From: Roger Frost [ferring-pc@btconnect.com]
Sent: 04 June 2008 08:50
To: Planning.Responses
Cc: Bryan McCansh
Subject: Re: Planning Consultation on: FG/69/08/ *SC*

ACK**OBJECTION - FG/69/08 - 34 Elm Park**

DRAWING NUMBER 14408.1A.

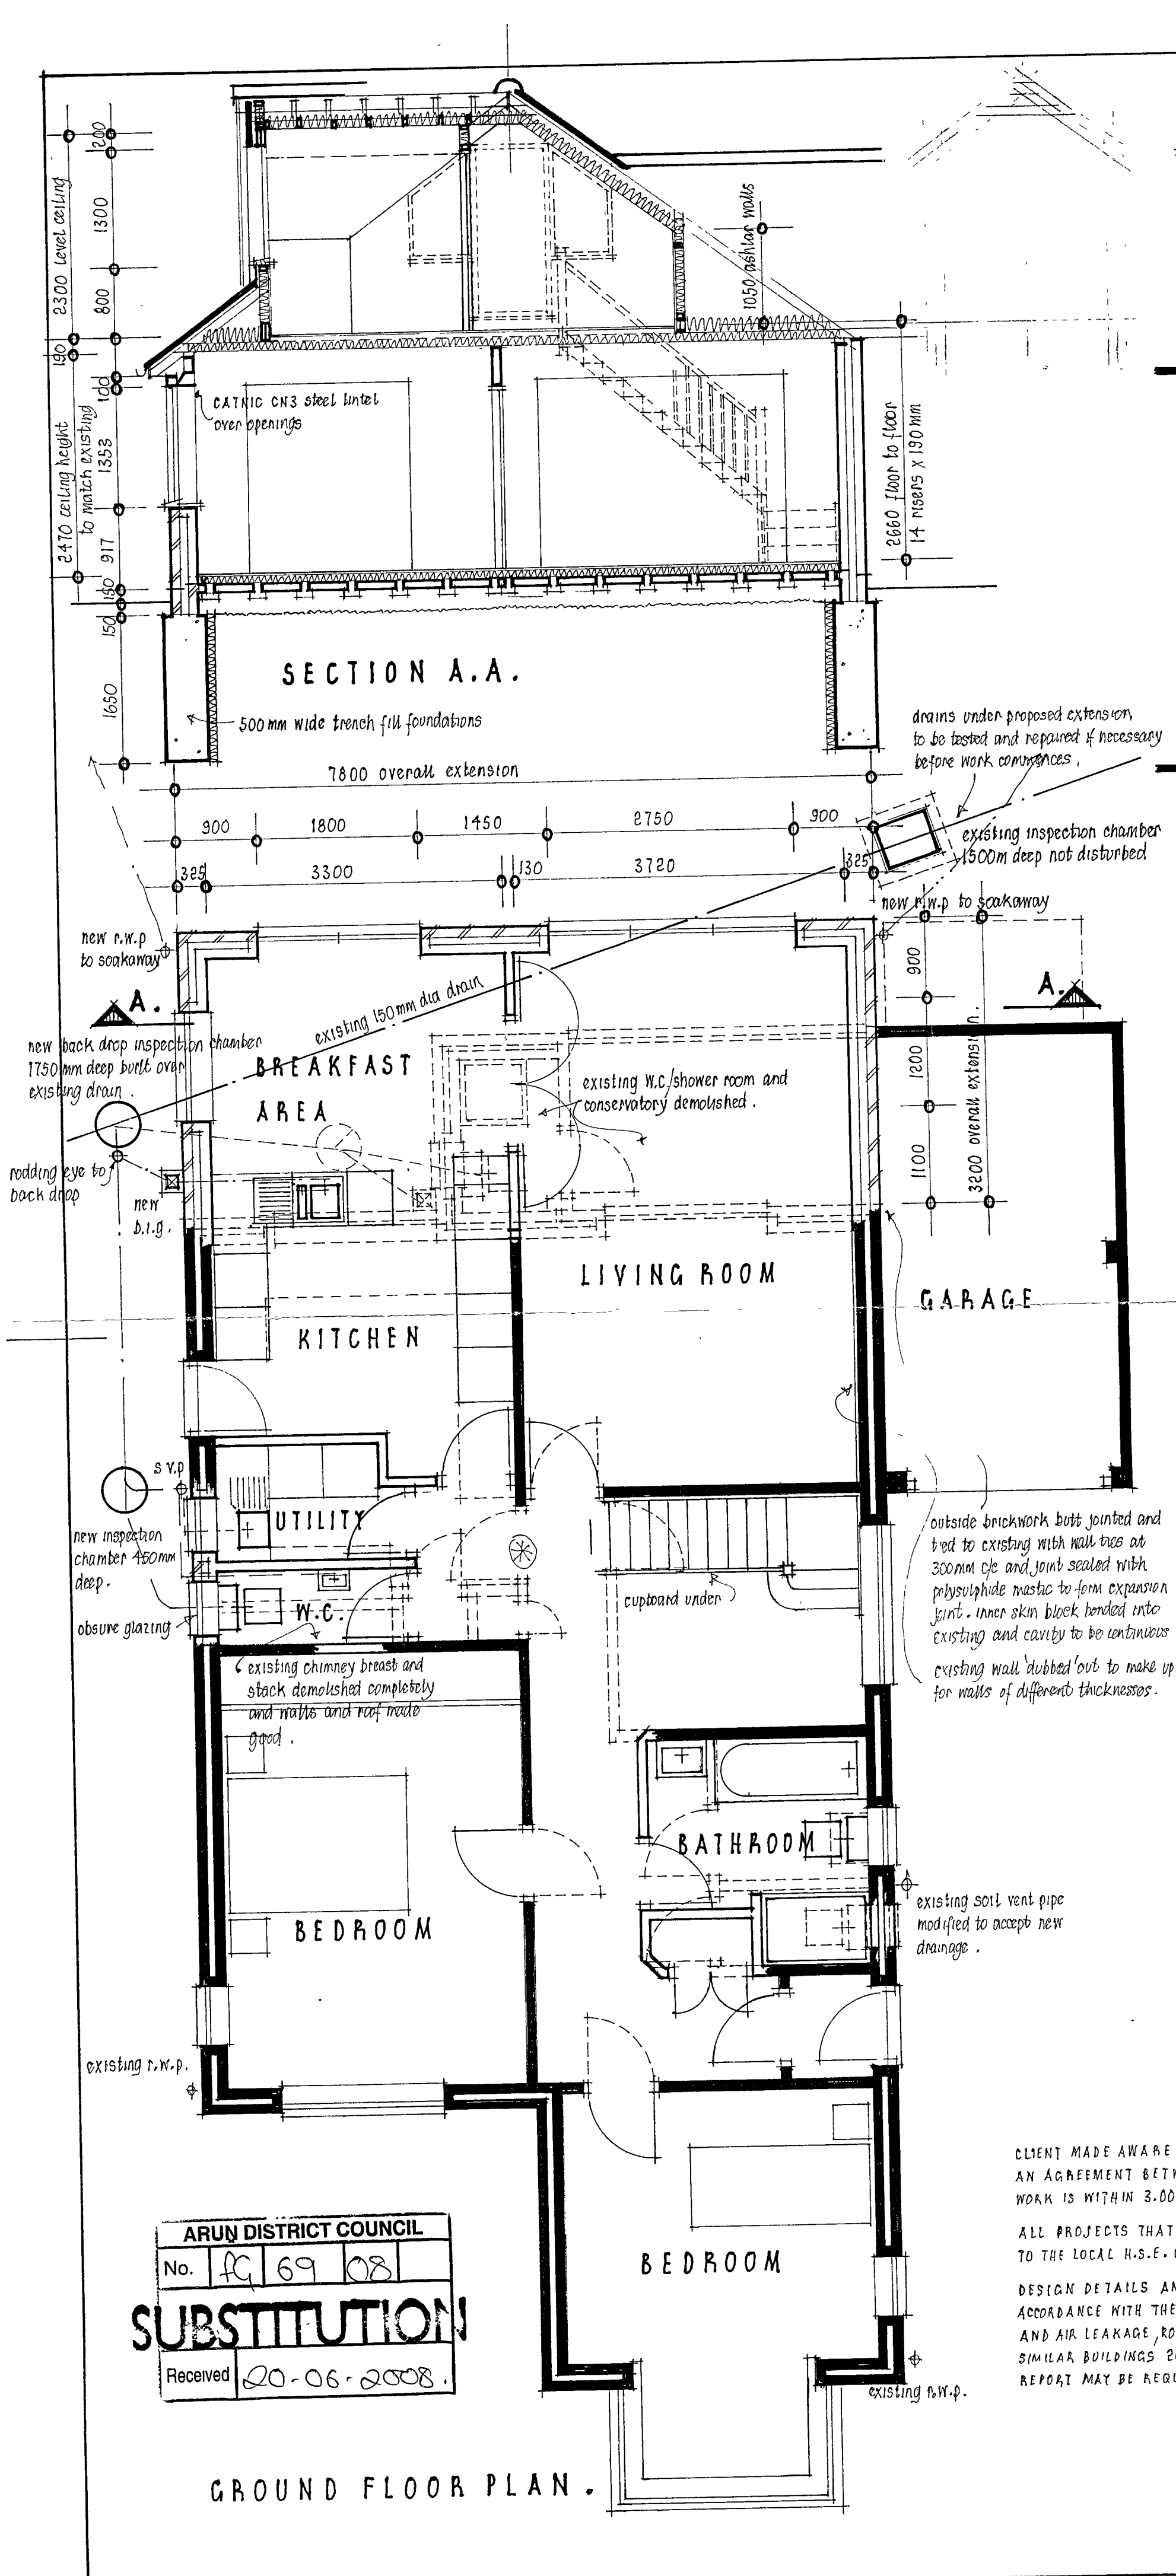
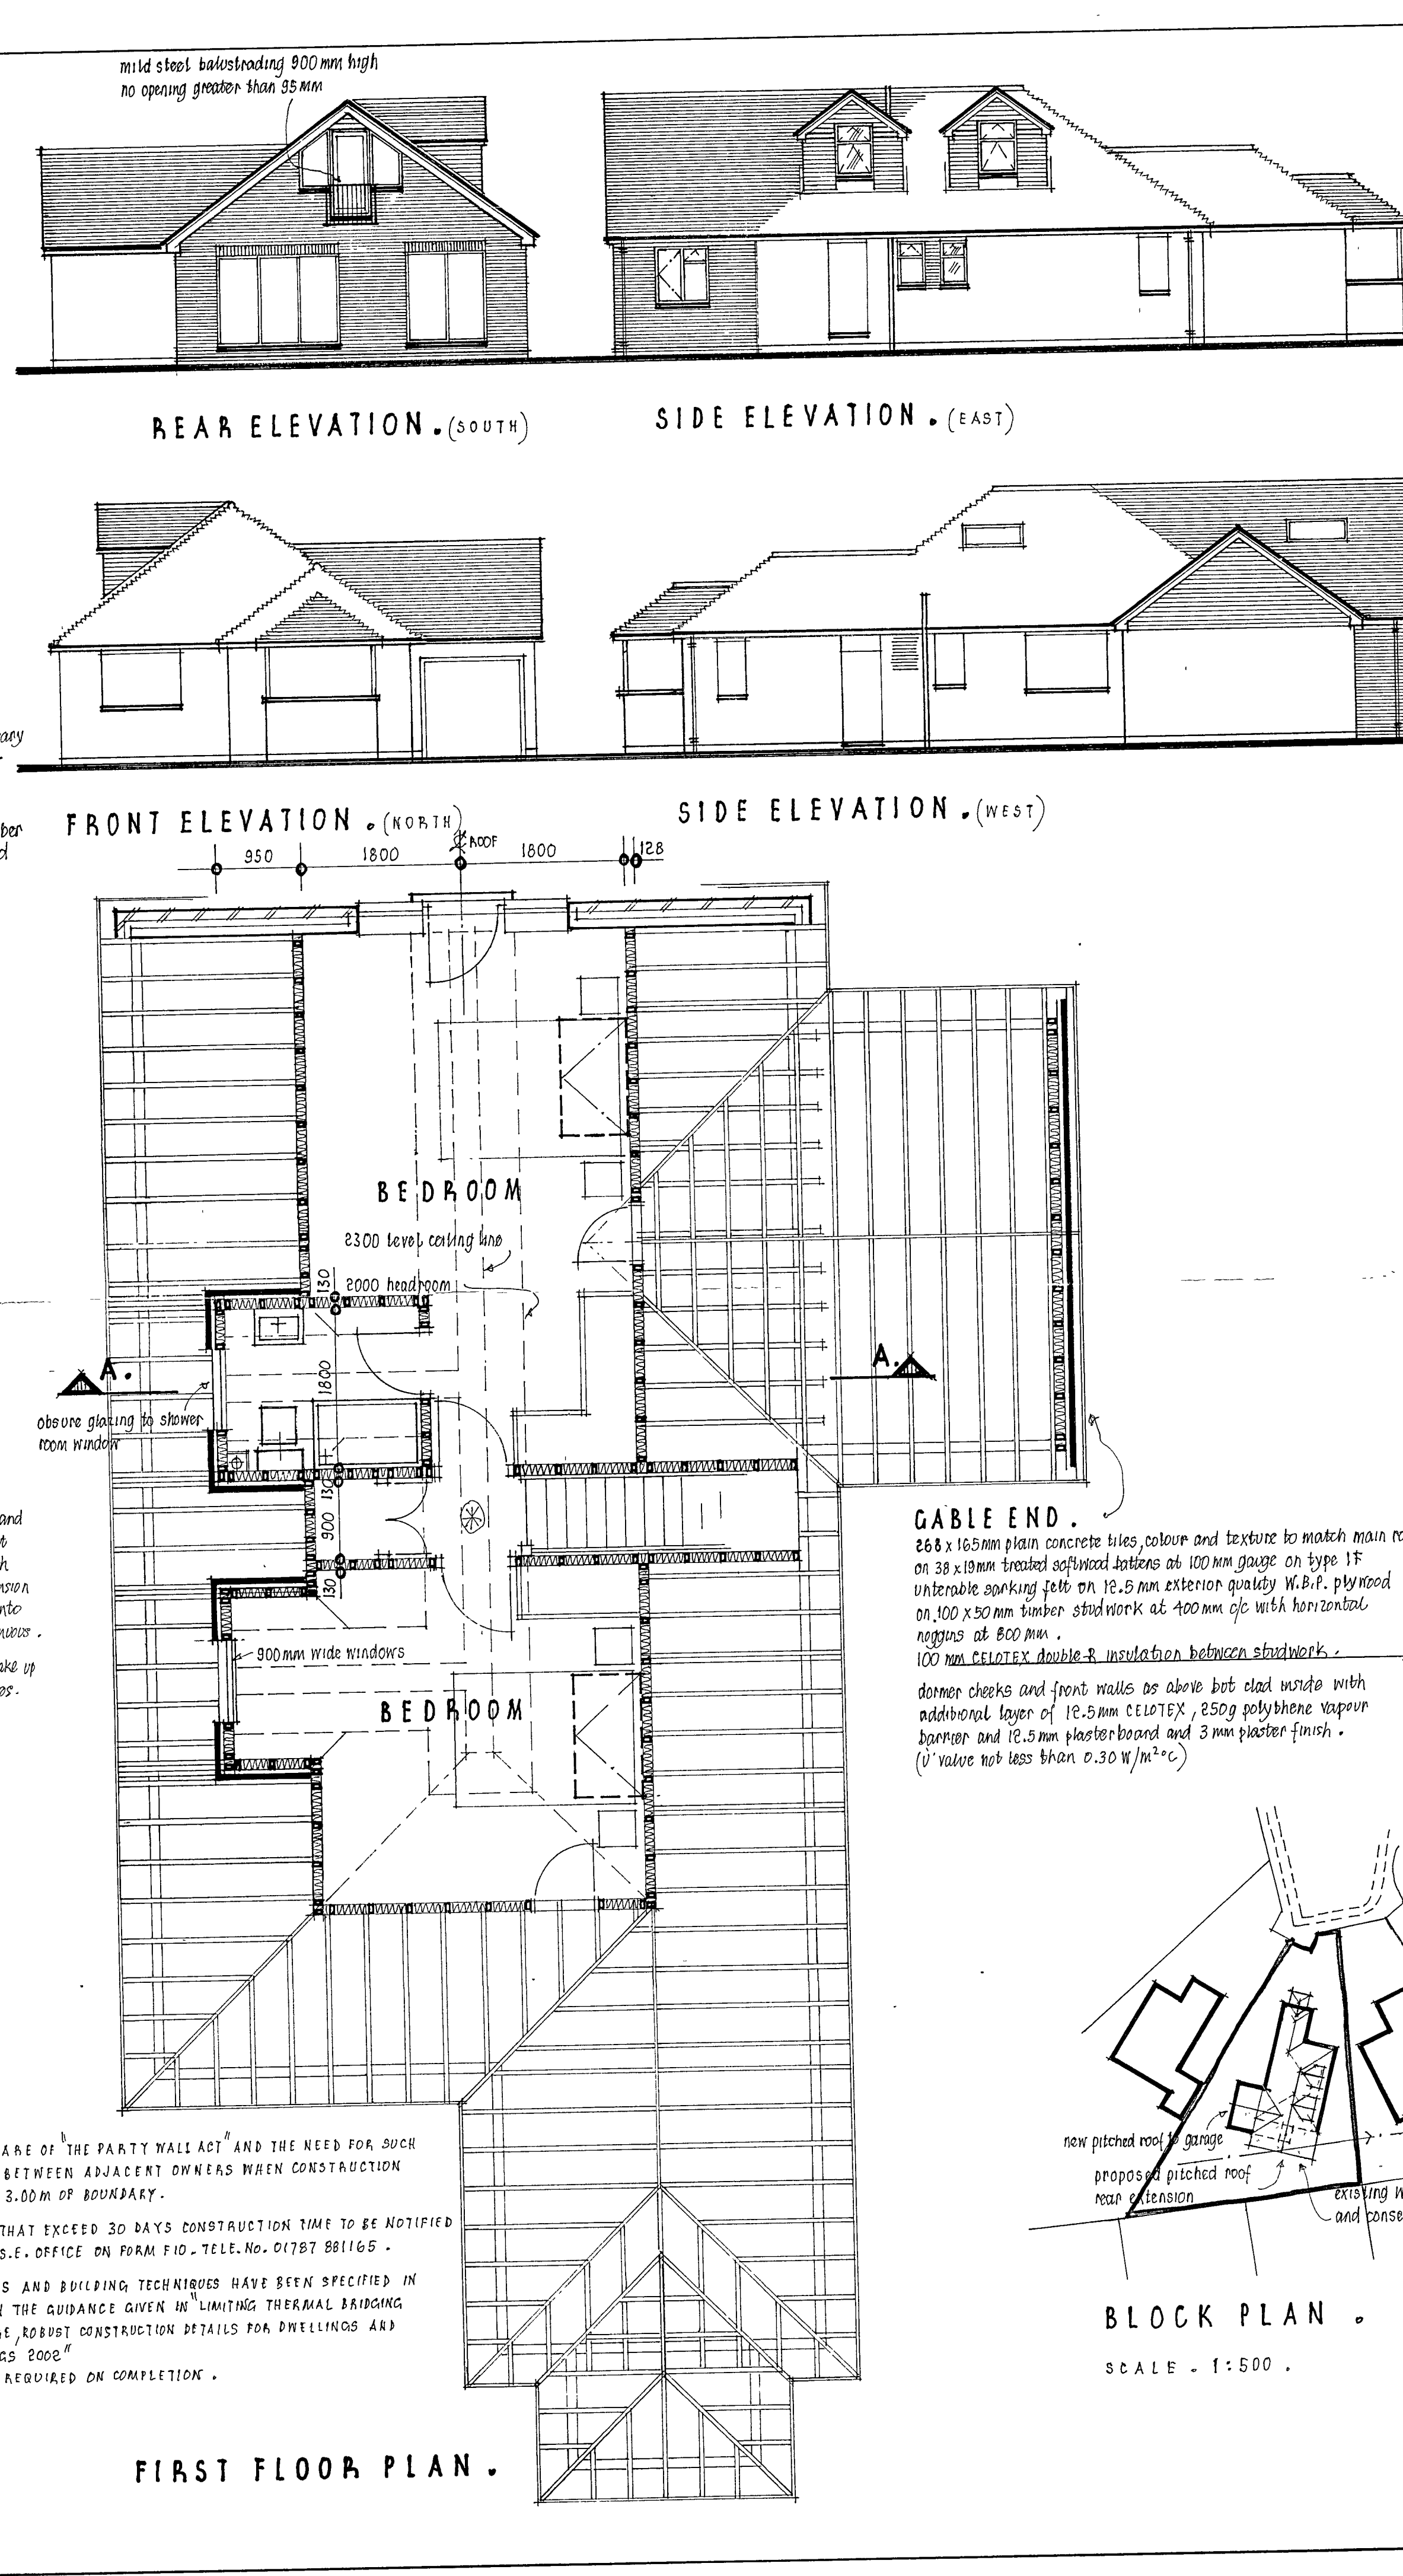
The three dormer windows on the side elevation overlook the house and garden of the adjoining property which does not accord with the provisions of GEN 7 (iv).
The Parish Council wishes to raise strong objection to this development.
